Recommendation Report for Planning Permission for Works or Extension to a Dwelling

REF NO: Y/47/19/HH

LOCATION: Normandie
Church Lane
Yapton
BN18 0EH

PROPOSAL: Single storey front extension, part two storey part single storey rear extension and alterations to fenestration. This application may affect the setting of a listed building.

DRAWING
EXISTING & PROPOSED
SIDE ELEVATIONS

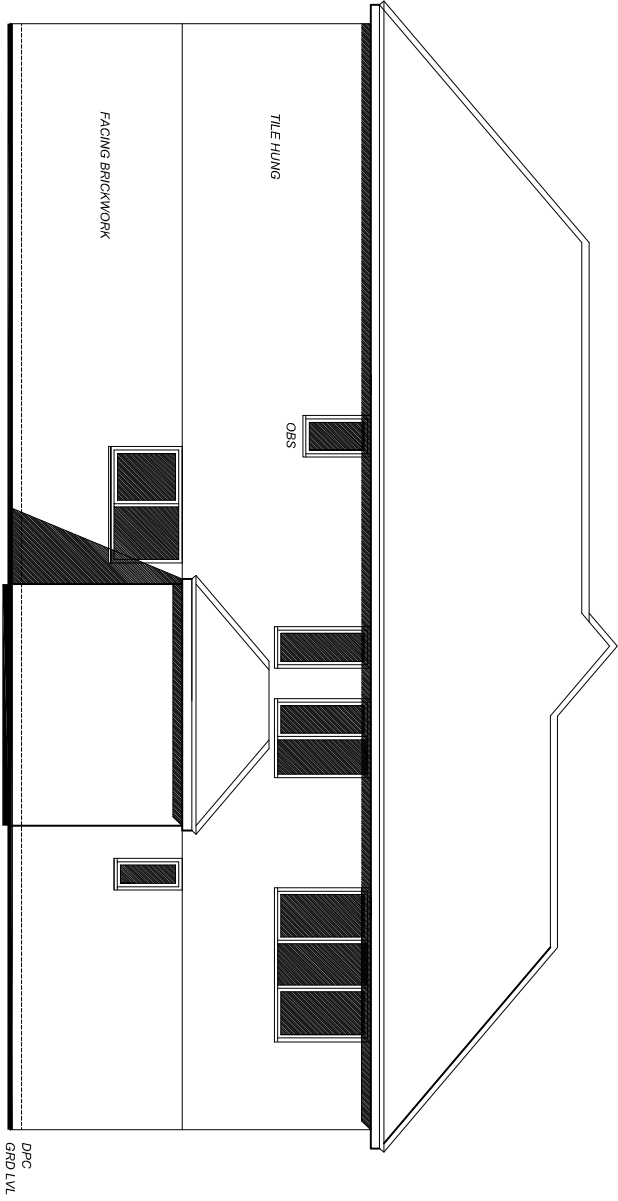
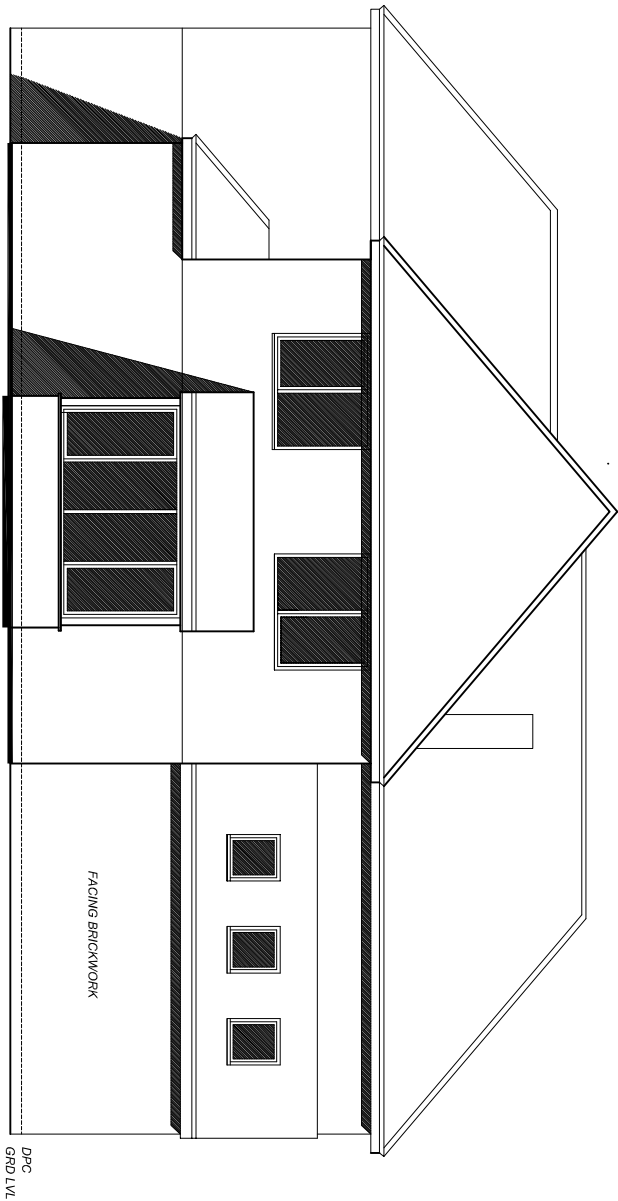
To the east and west elevation existing single storey additions will increase in height approximately 1m with the alteration from flat to pitched roof however the alteration is not considered to adversely impact neighbouring amenity, with sufficient boundary treatment in place also.

DRAWING
EXISTING & PROPOSED
FRONT & REAR ELEVATIONS

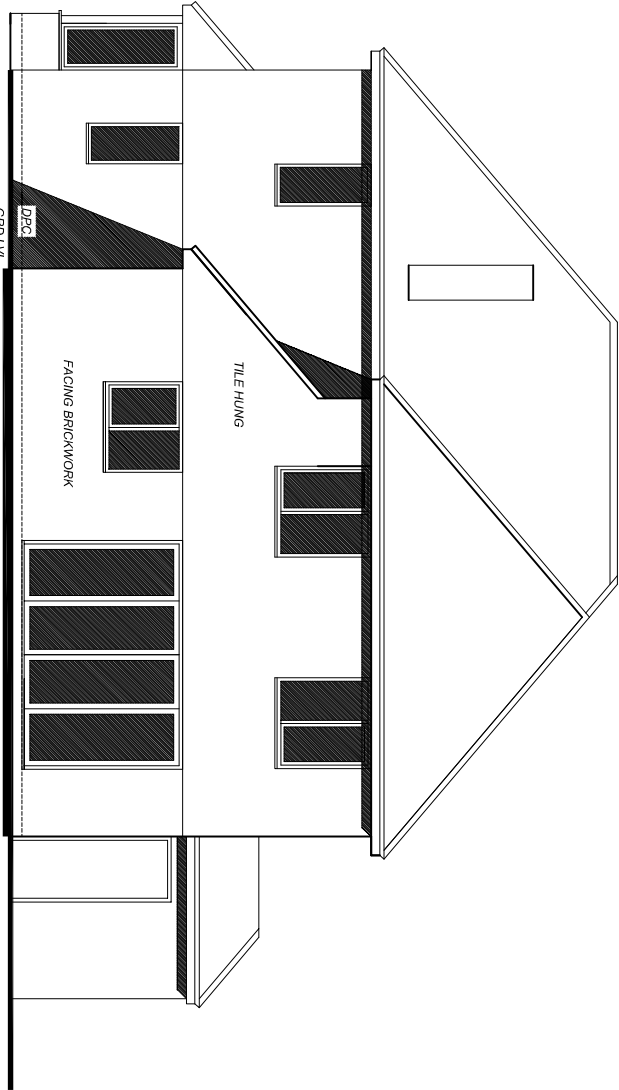
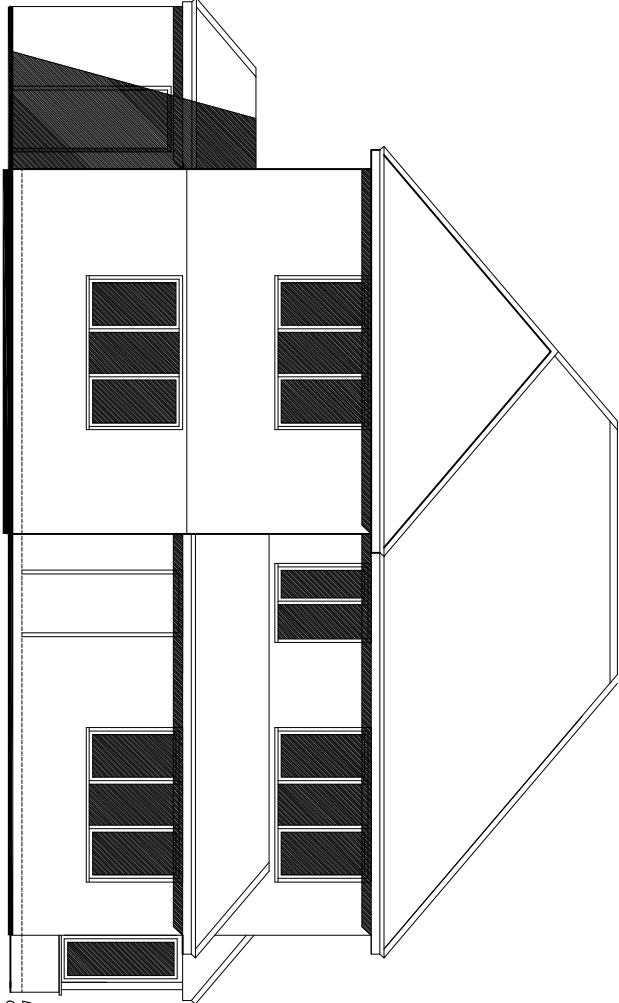
The proposed development is visible from the front elevation with the addition of a single storey front and side extension.

The proposal appears subservient and well integrated with the host dwelling. The dwelling is set back from the road and retains 18m to the front boundary, as a result the single storey front extension is not considered to appear unduly dominant on the street scene, with a pitched roof which is sympathetic in appearance to the host dwelling. The front extension will have a depth of 1.5m however this sits behind the principal elevation.

DRAWING
EXISTING & PROPOSED
FLOOR PLANS

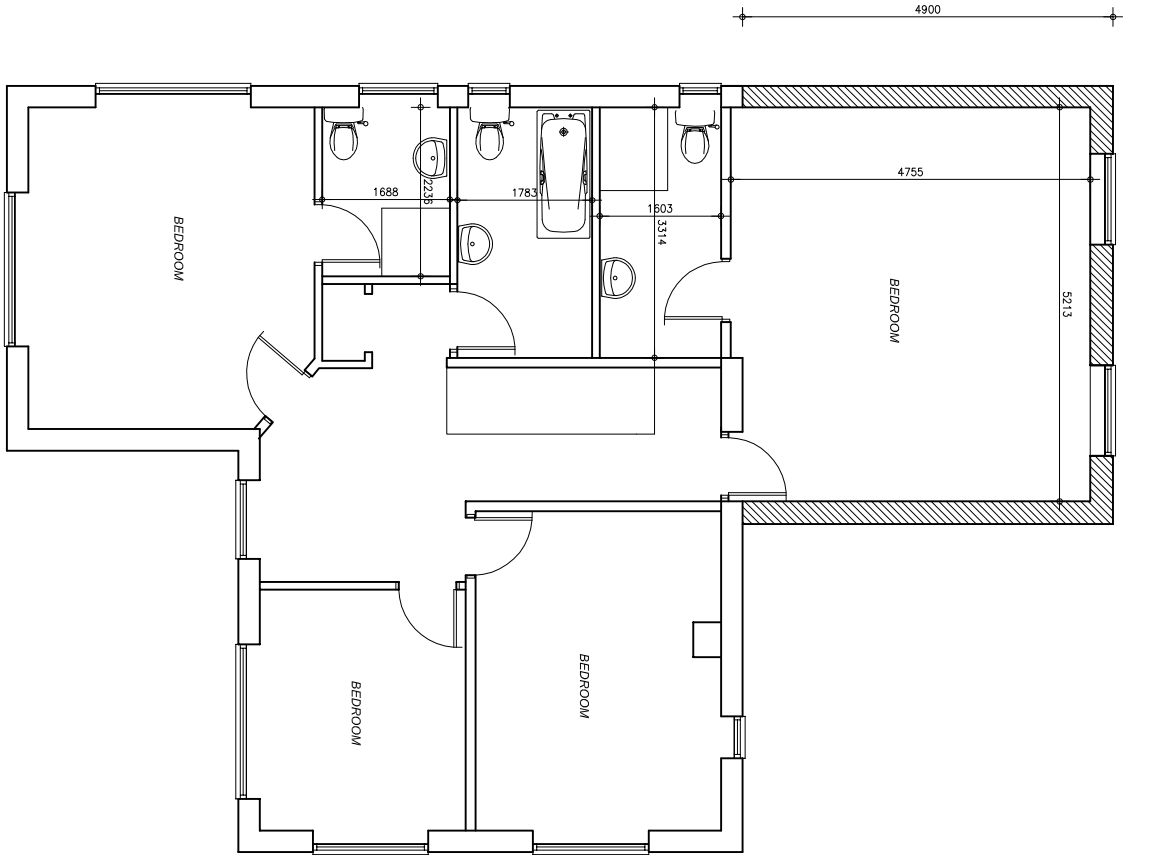
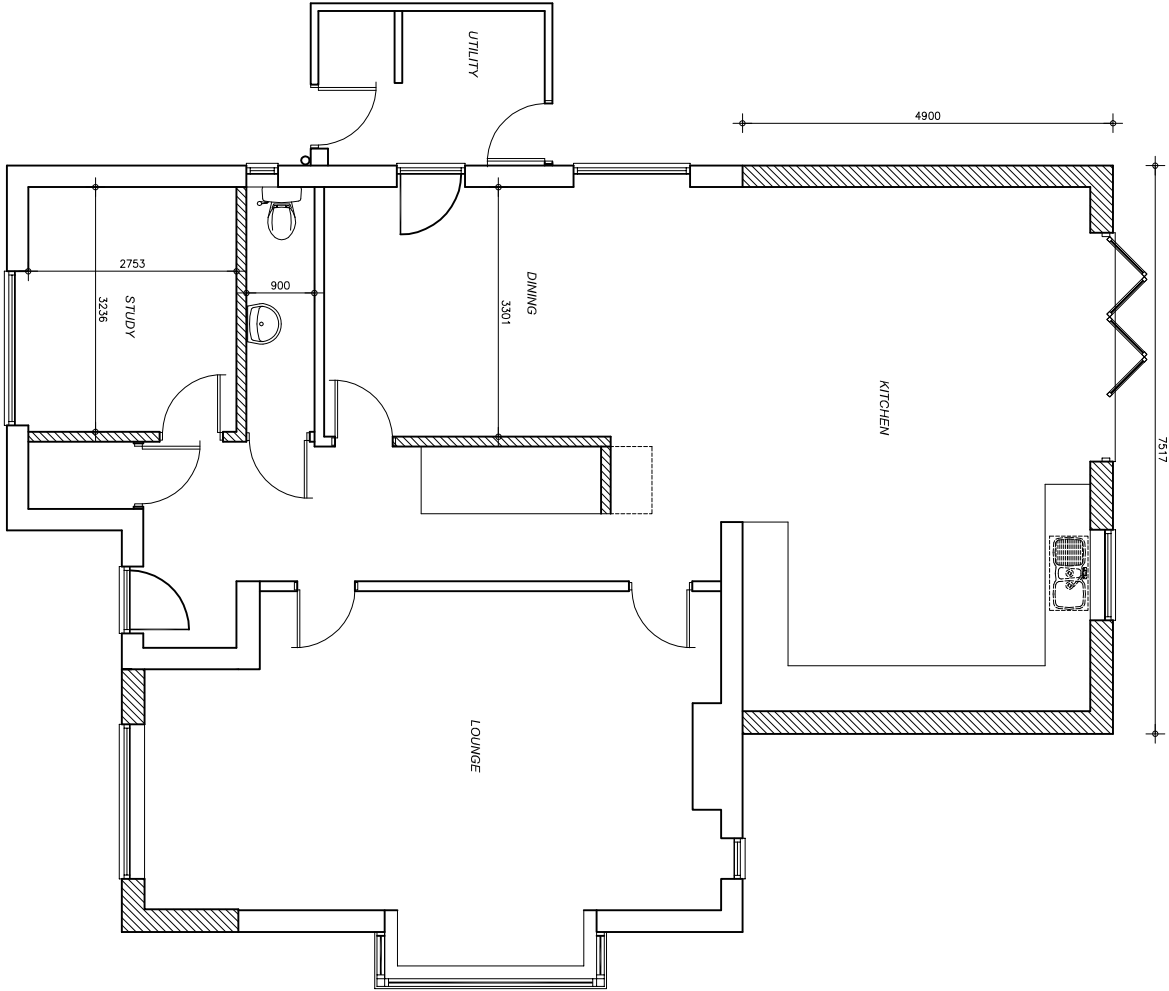
A part two storey and single storey extension will be constructed to the rear elevation. This will run along the western side to a depth of 4.9m and along the rear for a width of 7.5m with 5.2m forming two storey and the remaining reducing to single storey with a lean to roof. The height sits 0.5m below the host dwelling with eaves to match. 3 rooflights will be constructed to the single storey and due its height above ground floor will not give rise to adverse overlooking.

There will be 2 additional windows to the first floor extension facing north and due to the siting they are not considered to give rise to adverse overlooking upon neighbouring amenity with 15m retained to the

rear boundary. An additional window is also proposed to the first floor west elevation however is to be obscured as shown on the plan.

- 3 The first floor window on the west elevation of the building shall at all times be glazed with obscured glass and only openable at a high level, at least 1.7m above finished floor level.
